Your ref 3/2024/0187
Our ref DC/24/777
Date 03-APR-24

Location: Clayton Manor, Ribchester Road, Wilpshire, BB1 9HU.

Proposal: Proposed construction of four one-bedroom apartments in a purpose-built detached building

PROPOSED CLAYTON MANOR APARTMENTS SITE LAYOUT

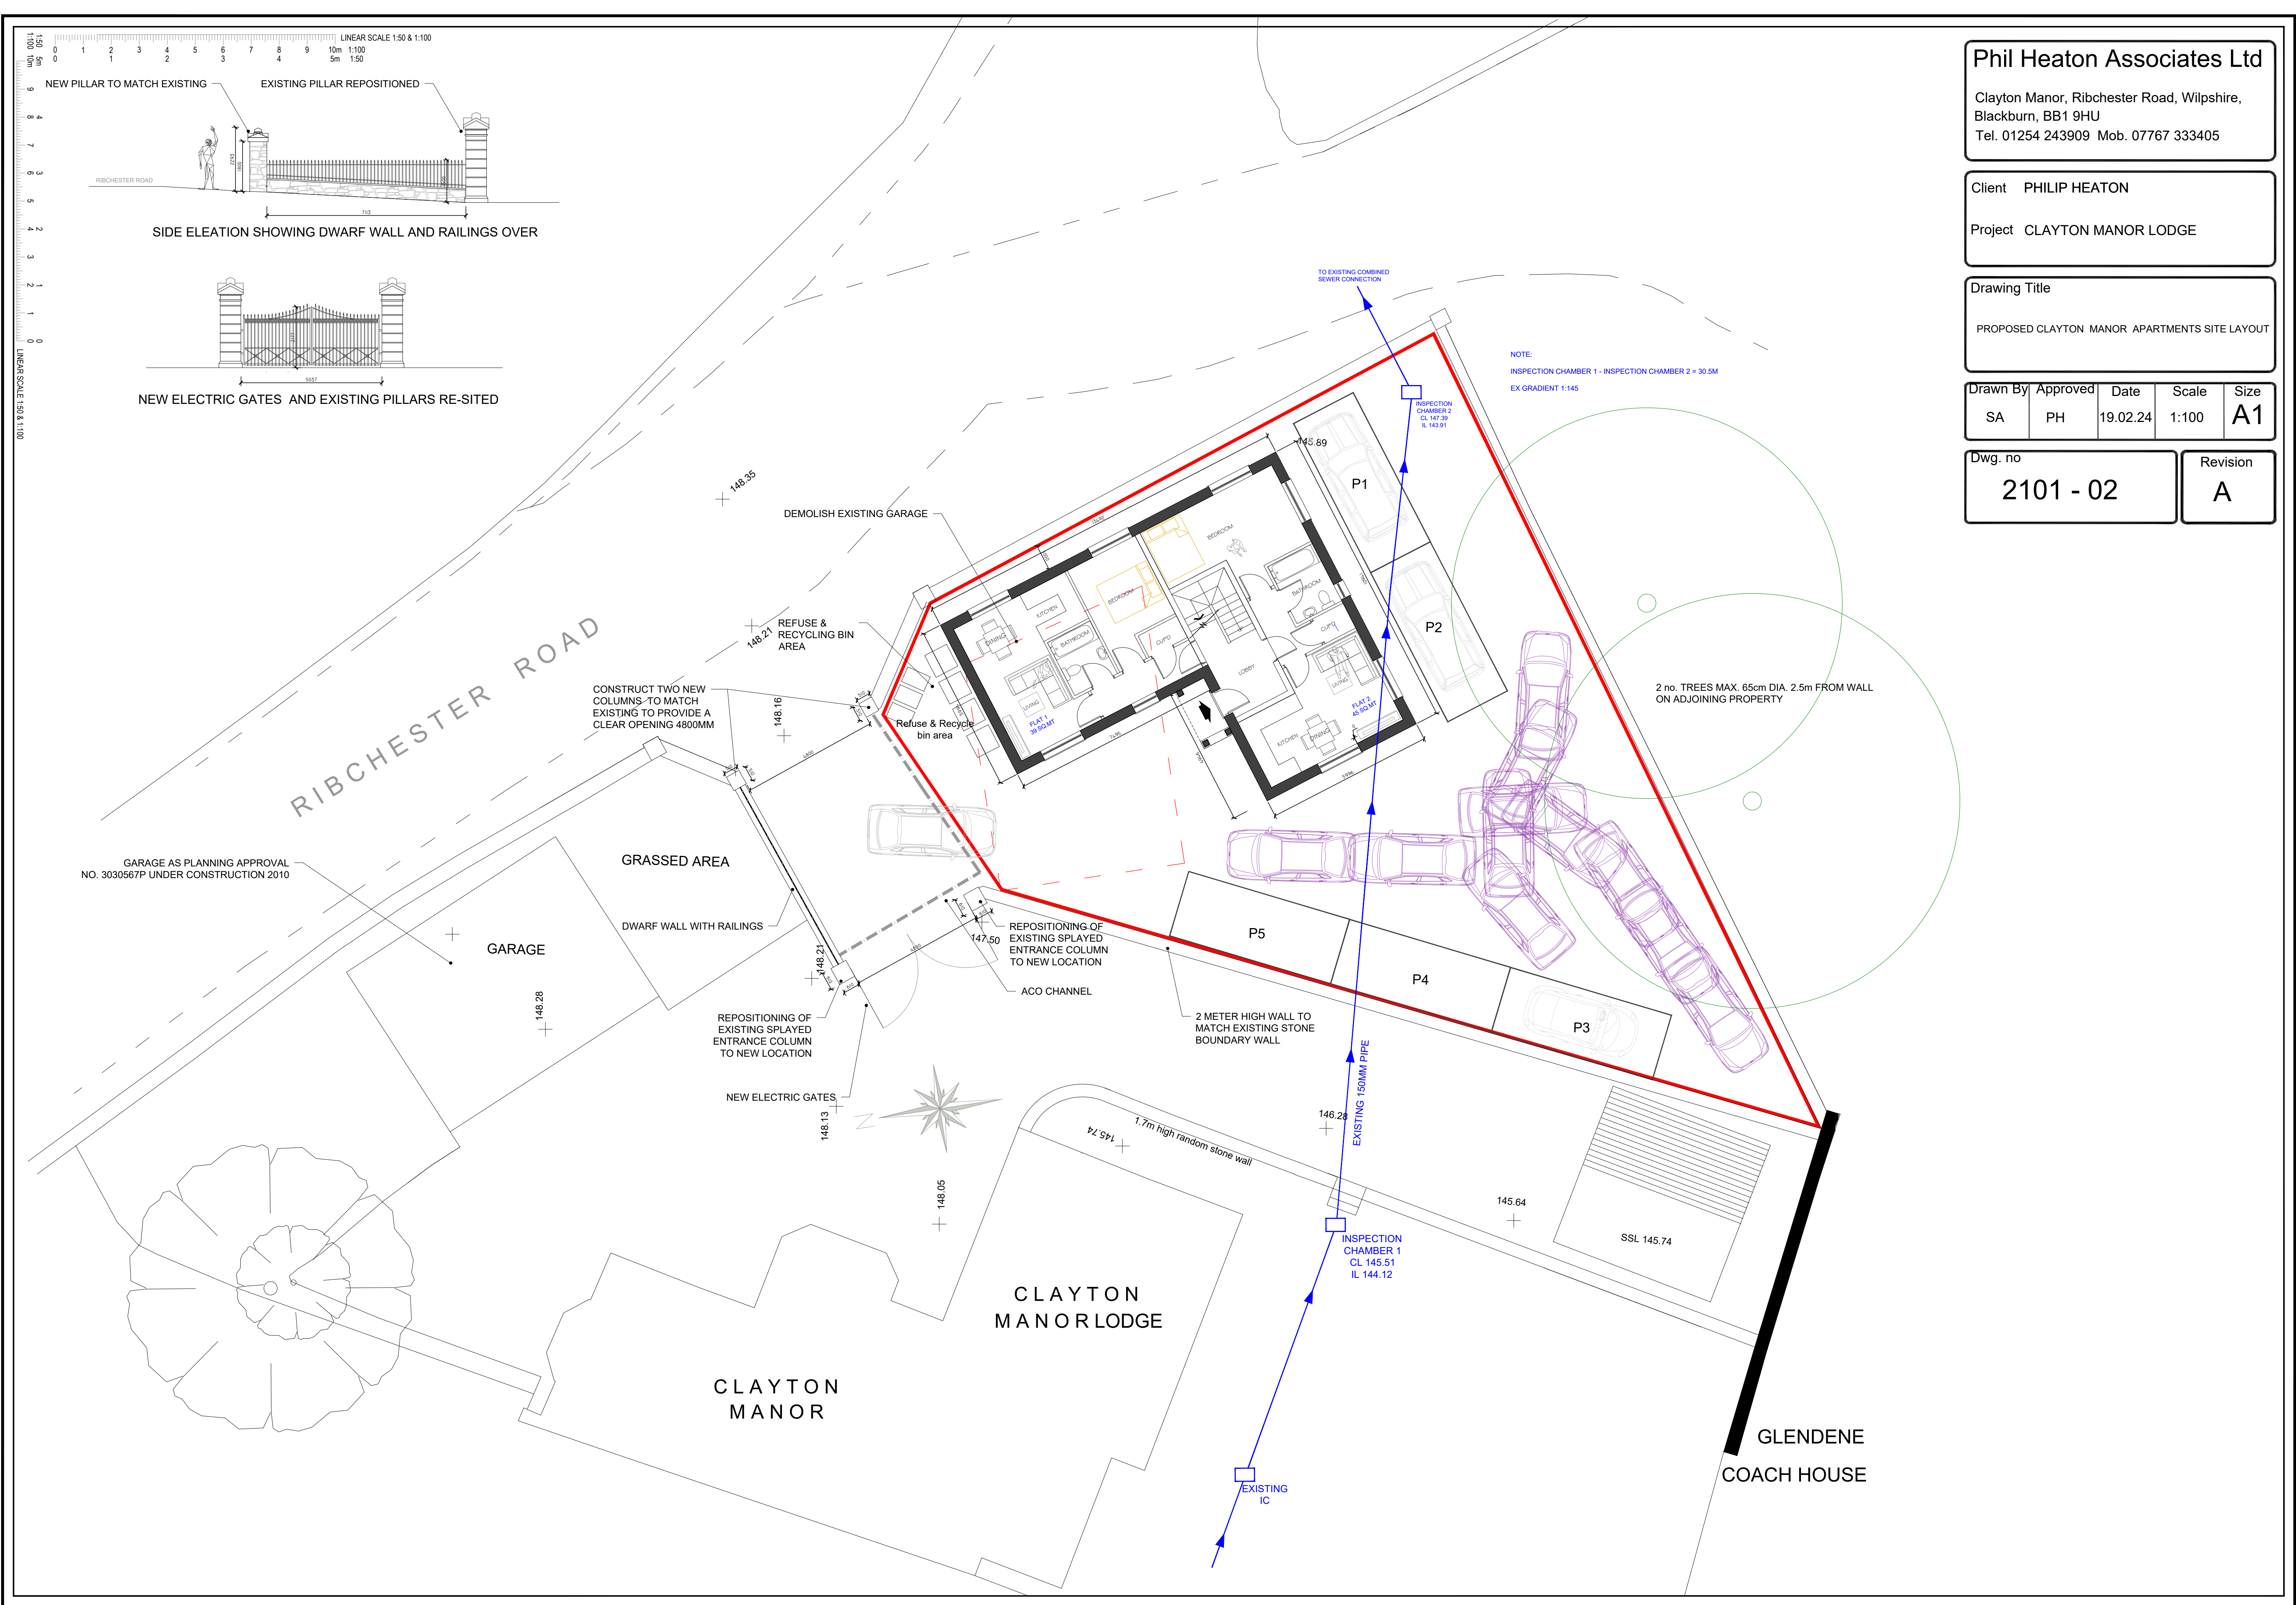
As the applicant and LPA are aware, a public sewer crosses the site and **we will not permit building over it**. We require an access strip for maintenance or replacement and this access must not be compromised in any way. The minimum distances that might be acceptable to United Utilities are detailed within Part H of the Building Regulations however, we recommend the applicant determines the precise location, size, depth and condition of the pipeline as this is likely to influence the required stand-off distance from any structure.

Following our review of the proposed site layout (Drawing No: 2101-02, REV: -, Date: 19.02.2024) it appears that our access to the sewer may be compromised and this will require resolution **prior to commencement by the applicant**. We recommend the applicant seeks advice on this matter from our Developer Services team at the earliest opportunity as a diversion of the affected public sewer may be necessary.
